**WEST SUSSEX COUNTY COUNCIL
STRATEGIC PLANNING CONSULTATION**

DATE: 25/10/2017

**SUBJECT: LU/282/17
Land north of and south of the railway
Courtwick Lane, Littlehampton**

Block Plan

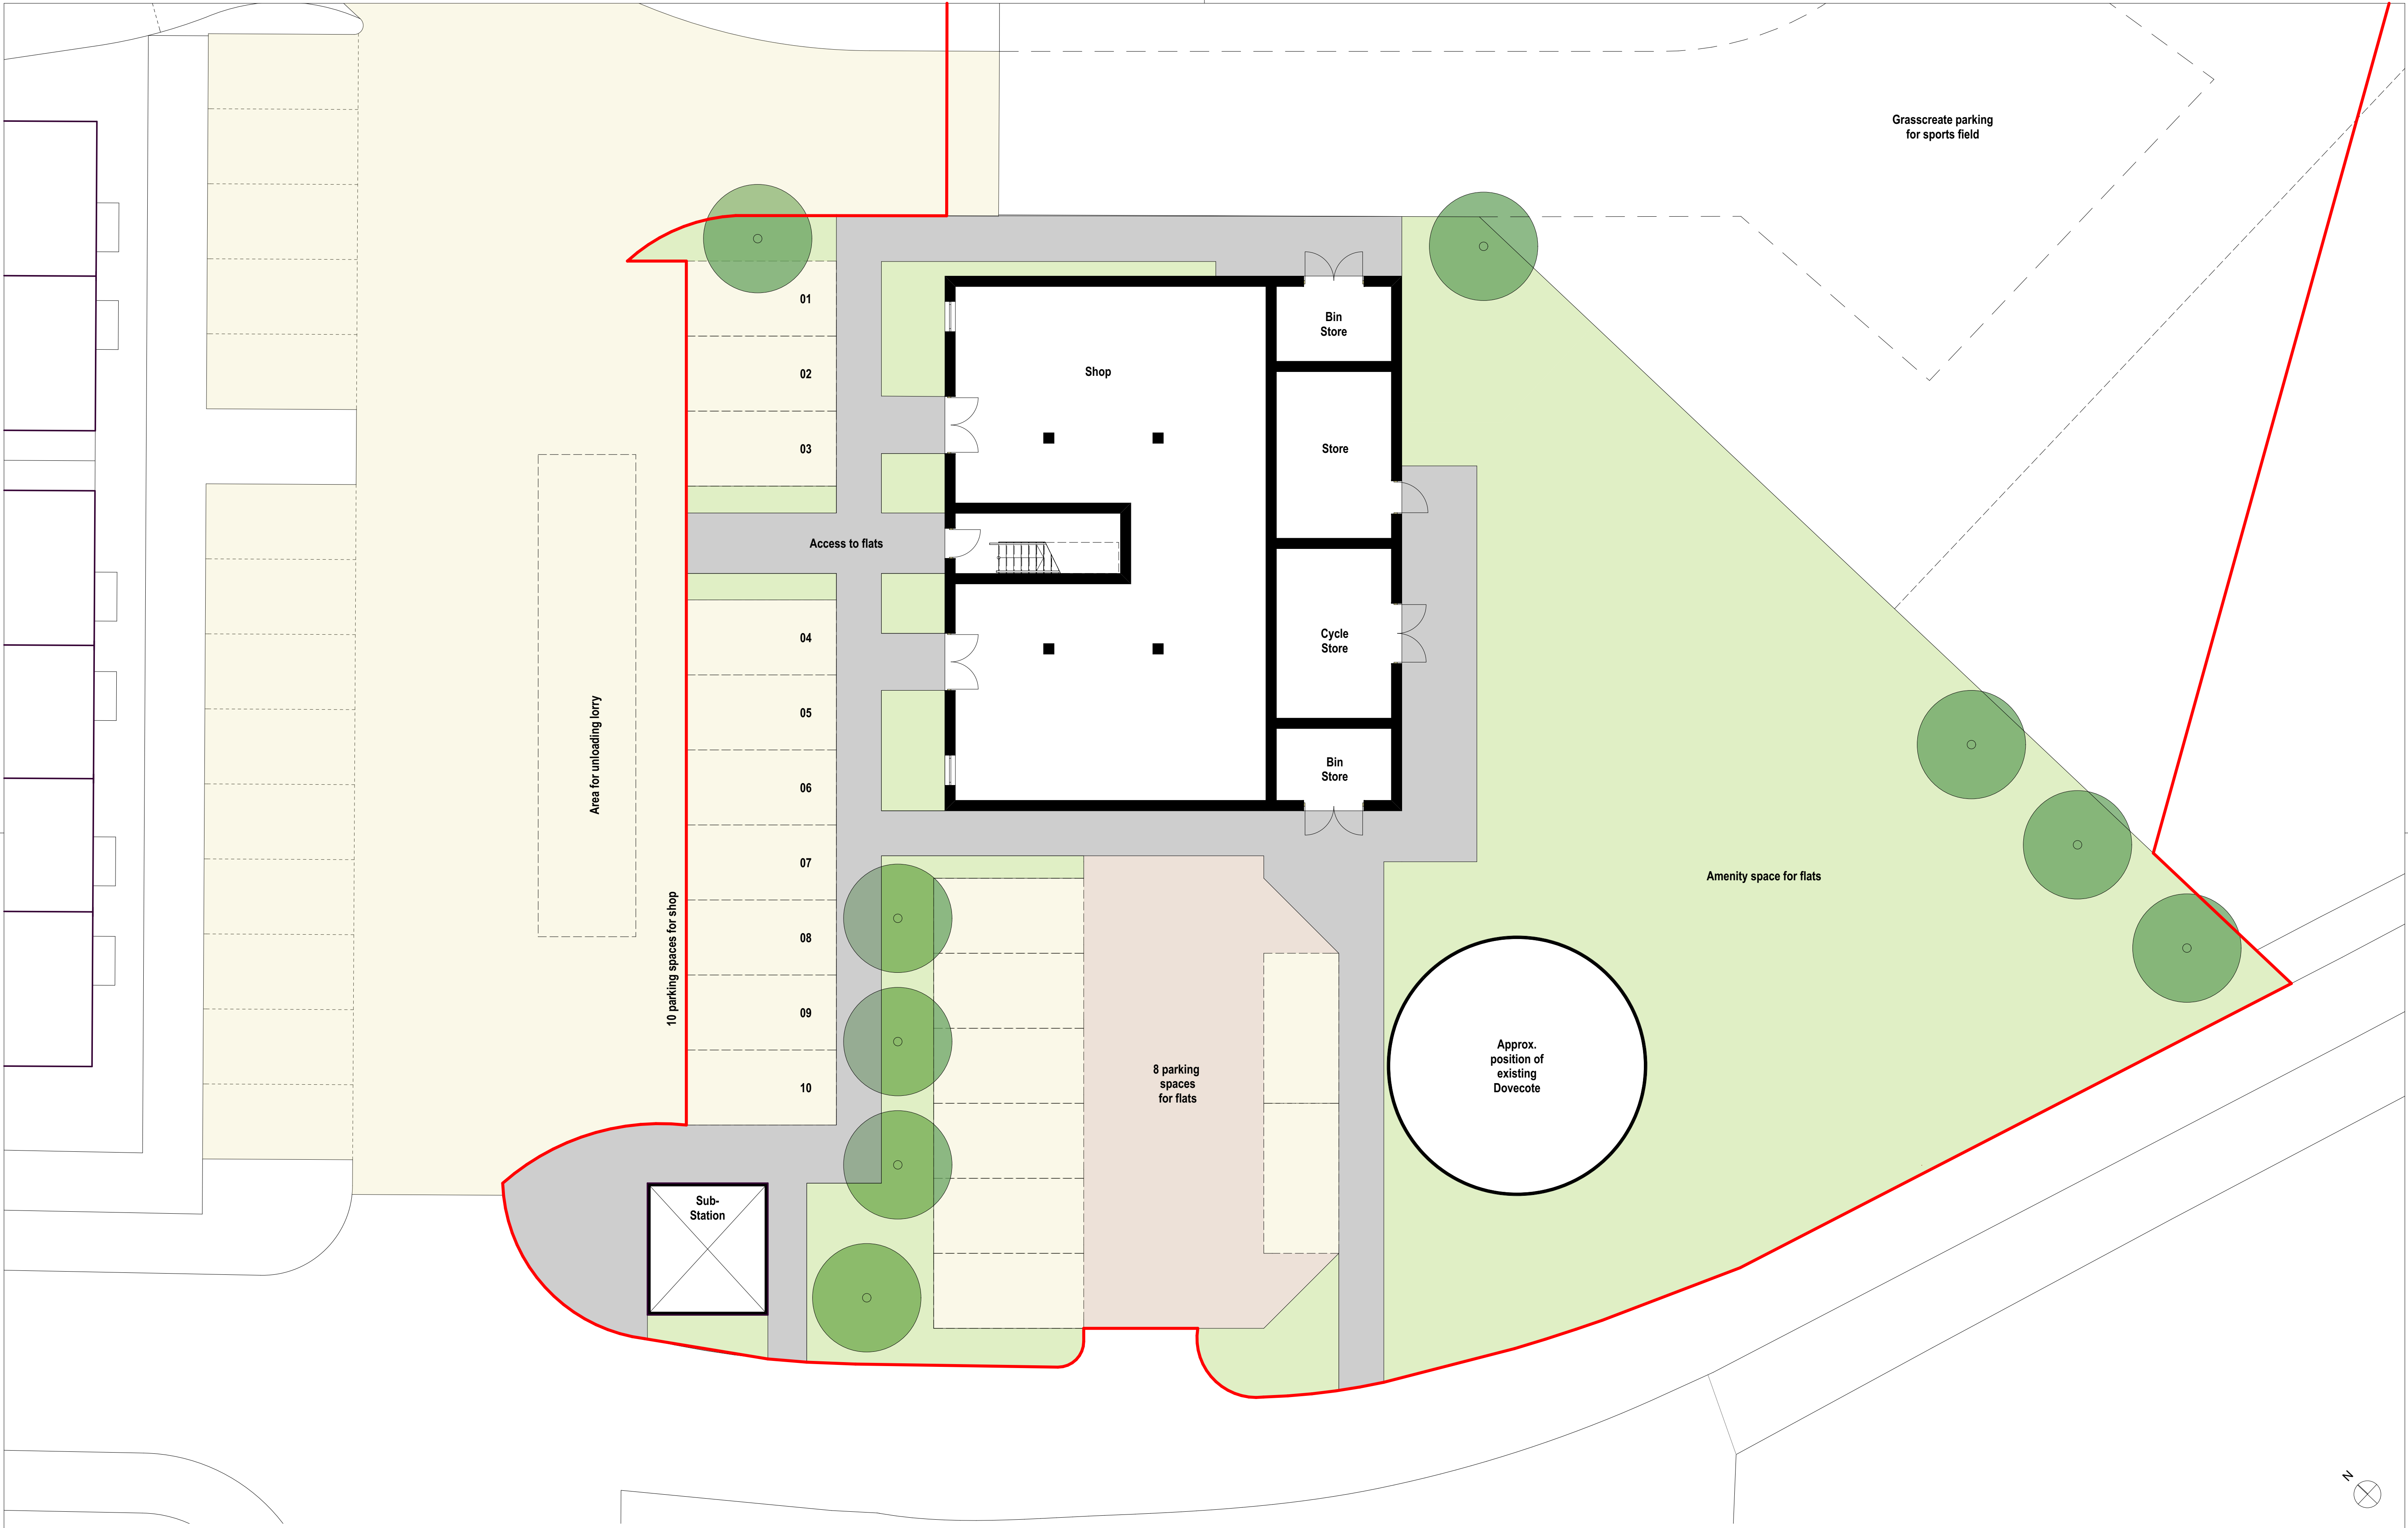
10 Spaces are allocated to the mixed use building, and an additional 8 spaces have been allocated for the 5 flats. This includes an allocation of 1 space per flat and 3 spaces for visitors.

All of the proposals are in line with current guidance. It is noted that local concern over the number of vehicles using the site for the sports pitch is a local concern. The proposals are to provide a grasscrete area for up to 20 cars to park on match days. This would also provide a flexible parking area for the A3 use. WSCC are unable to determine if this would be an appropriate number as it is unclear how many pitches there will be. Although car sharing is often common practice or the use of mini buses for these types of activities would reduce the number of vehicles entering and exiting the site.

We would advise should further parking be required from this use it is most likely that people would park on the grass if more space was required, and could be made larger at a later date if needed.

It is noted that access to the site from both roads could cause congestion issues and at busy times there could be issues with the width of Courtwick Lane, as once it becomes private it also becomes single width.

The main preferred route would be into the site via Benjamin Gray Drive with the possibility of exiting via Courtwick Lane as a voluntary one way system to help at times when the volumes of traffic may be higher i.e. on match days.
